Our Ref: R/63/15/HH

Single storey side extension
18 Sheep Fold Avenue Rustington

Thank you for your internet representation made on 10th May 2015 which has been recorded as '**an objection**' with the comments as follows:

Proposed Extension
18 Sheepfold Avenue
Rustington
BN16 3SQ
Scale 1:100 (A3)

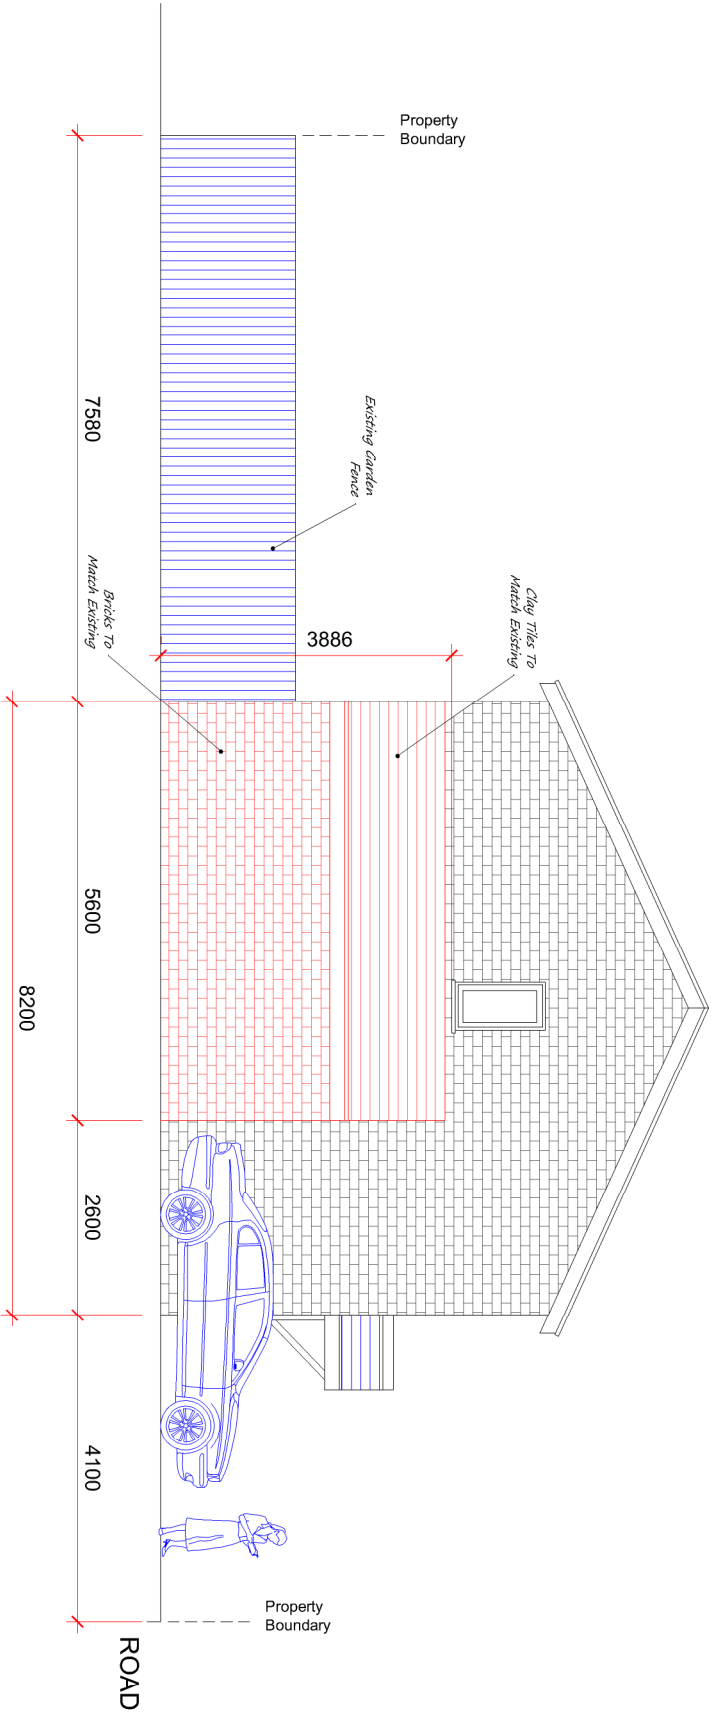
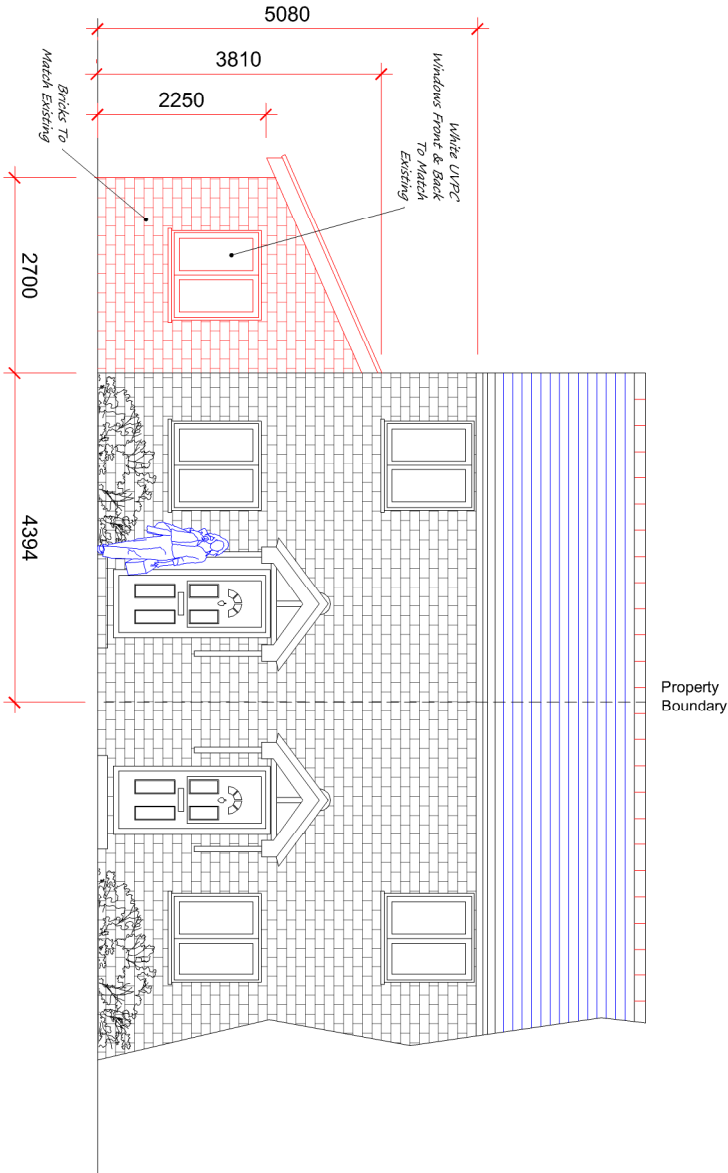
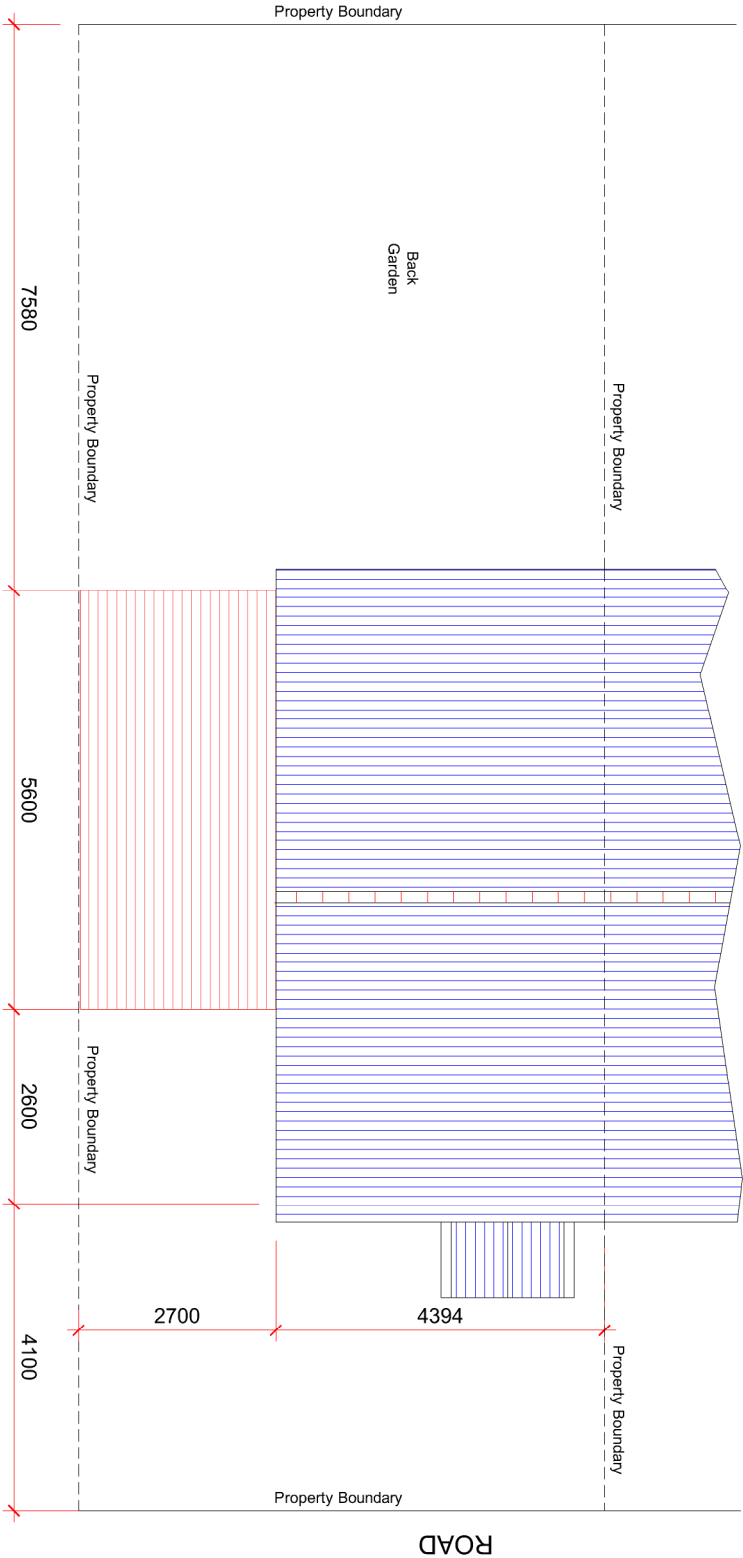
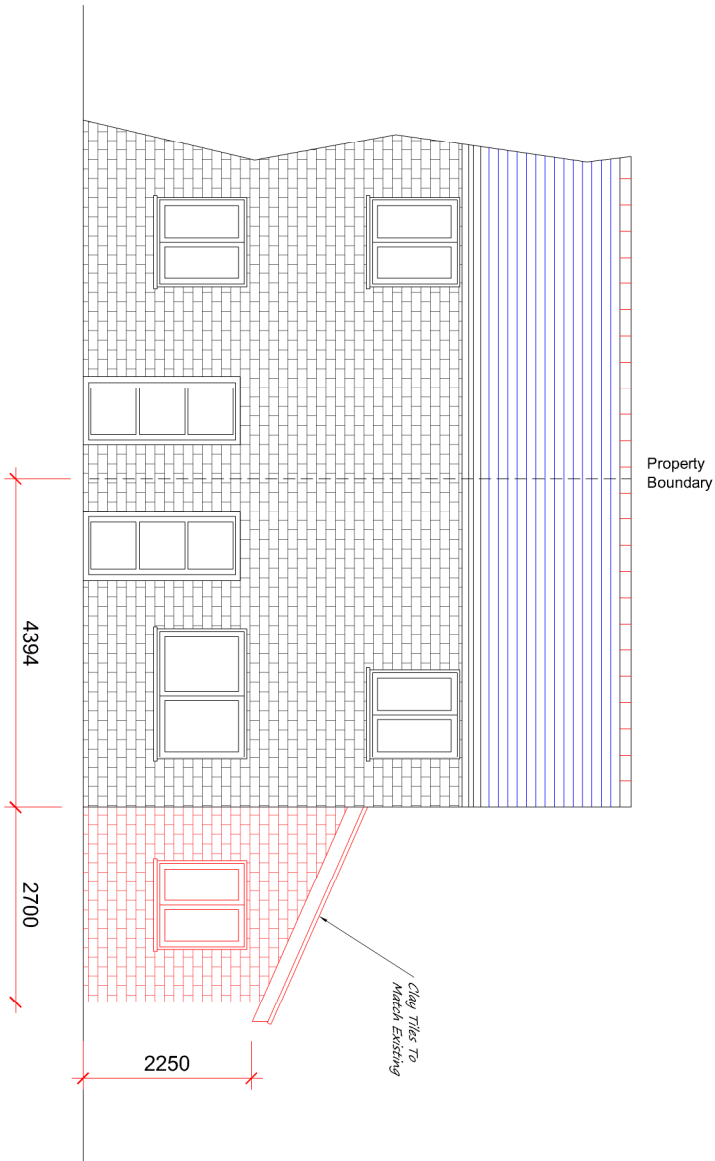
Dear Sir/Madam, the council and the applicant should be aware that the road (including the pebbled area) adjacent to the proposed extension is private property and if the current application is allowed the extension will not be confined within the applicants property boundary as the soffit, fascia, gutter and part of the roof will be overhanging past their boundary line. I would propose, therefore, that the width of the proposed extension be reduced so that the overhang is entirely within their boundary. Yours truly, Stephen Gunner
